## **El Paso County Park Advisory Board**

### **Agenda Item Summary Form**

**Agenda Item Title:** Meadowlake Ranch Sketch Plan

**Agenda Date:** October 12, 2018

MEADOWLAKE RANCH SKETCH PLAN

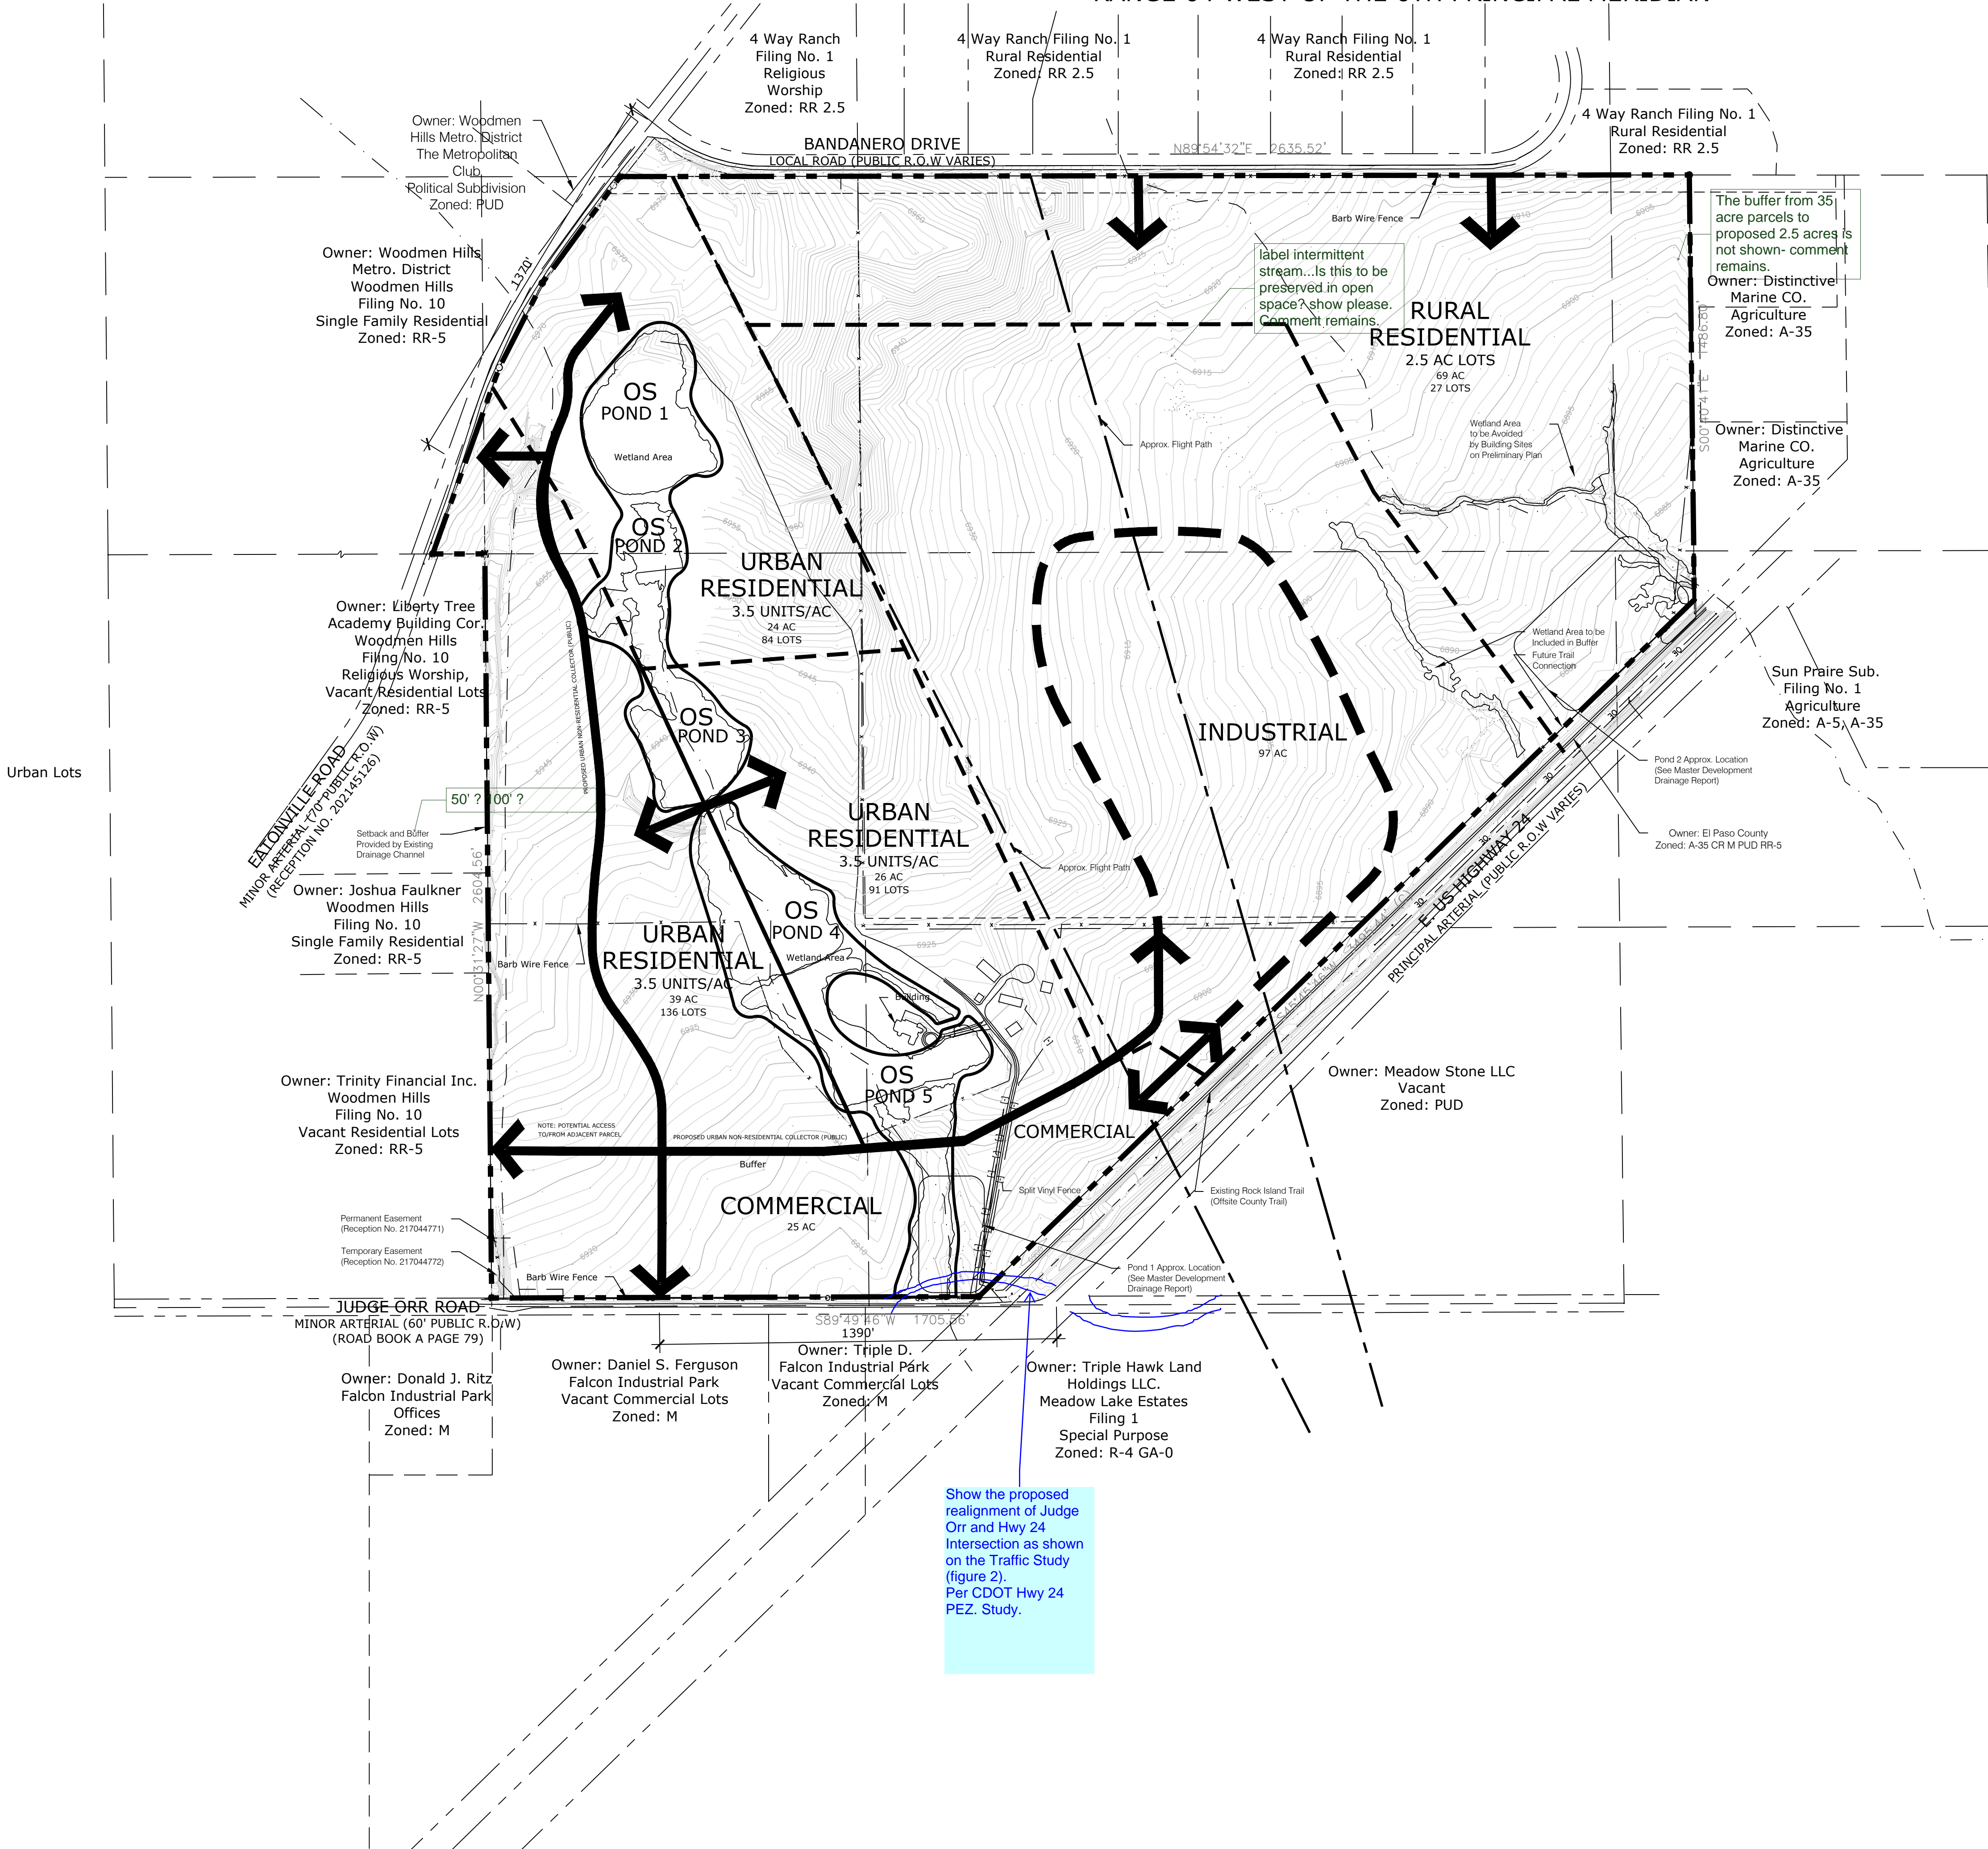
The Meadowlake Ranch Sketch Plan currently shows 24.4 acres of open space, dedicated primarily to the protection of an existing drainage and wetlands area. This constitutes approximately 8% of the total project area of 307.3 acres. At this time, no other open space areas, parks, or trails are depicted in the Sketch Plan, nor is there mention of them in the Letter of Intent. Dependent on the final zoning classification, Meadowlake Ranch may or may not be obligated to conform to the El Paso County Land Development Code 10% open space requirement.

Staff recommends that the developers, through forthcoming preliminary plans and final plats, designate and provide to El Paso County 25-foot trail easements along Eastonville Road, as well as along Judge Orr Road for the purpose of construction and maintenance of the Eastonville Primary Regional Trail and the Judge Orr Secondary Regional Trail, respectively. Staff also encourages the developers to consider the addition of open spaces, neighborhood,

and community parks, so as to provide recreational opportunities for residents and visitors of Meadowlake Ranch. Furthermore, staff encourages the developers to construct internal trail systems that link residents not only to these possible neighborhood and community parks, but also to the County's surrounding regional trail system.

Recommend to the Planning Commission and the Board of County Commissioners that the approval of Meadowlake Ranch Sketch Plan includes the following conditions: (1) the developer is encouraged to explore urban park options in the form of additional open space areas, trails, community parks, neighborhood pocket parks or other recreational opportunities; (2) designate and provide to El Paso County a 25-foot trail easement along Eastonville Road, that allows for public access, as well as construction and maintenance by El Paso County of the Eastonville Primary Regional Trail; (3) designate and provide to El Paso County a 25-foot trail easement along the north side of Judge Orr Road, that allows for public access, as well as construction and maintenance by El Paso County of the Judge Orr Secondary Regional Trail; (4) the easements shall be shown on all forthcoming preliminary plans and final plats, and the aforementioned easements shall be dedicated to El Paso County on the forthcoming final plat(s); (5) fees in lieu of land dedication for regional and urban park purposes will be calculated upon review of forthcoming preliminary plans and final plats, and will be required at time of the recording of the forthcoming final plats. A park lands agreement may be an acceptable alternative to urban park fees provided the agreement is approved by the County and executed prior to recording the forthcoming final plats.
